**CATALYST BICESTER - LAND ADJACENT TO PROMISED LAND FARM, WENDLEBURY ROAD  
PLANNING APPLICATIONS REFERENCES: 19/01740/HYBRID & 19/01746/OUT**

**'Catalyst Bicester', Promised Land Farm, Wendlebury Road, Bicester  
Review of Submitted Transport Assessment**

Project: Catalyst Bicester Transport Review  
Prepared by: David McMurtary  
Approved by: Phil Bell  
Date: 17<sup>th</sup> October 2019

Figure 8.1 – Health and racquets Club Layout

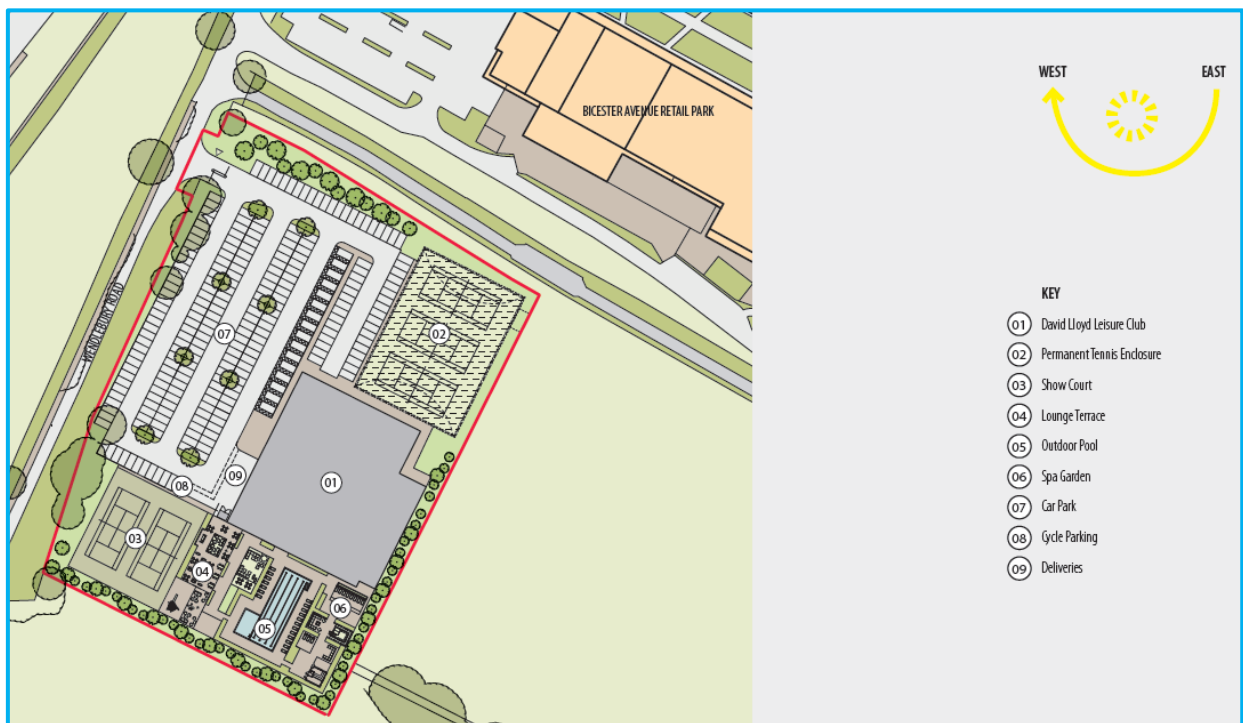
- 2.16 The proposed health and racquet club would accommodate a 1.6 hectare portion of the overall site, and accommodate 246 parking spaces. The travel demands generated by the club have been estimated using the TRICS database.

- 2.17 The provision of 246 parking spaces for the Leisure and Racquet Club suggest an expectation that the club will attract a high number of cars at any one time. Anticipated vehicular trip attraction associated with the club is shown within Table 15 in the Transport Assessment, which is relatively low when considering the parking provision proposed.

- 2.18 Whilst the TA does not specifically reference the intended leisure and racquet club operator, it is clear from additional supporting information (in particular the architectural plans) that the intended operator is David Lloyd, which could result in a higher than average trip attraction compared to other operators.
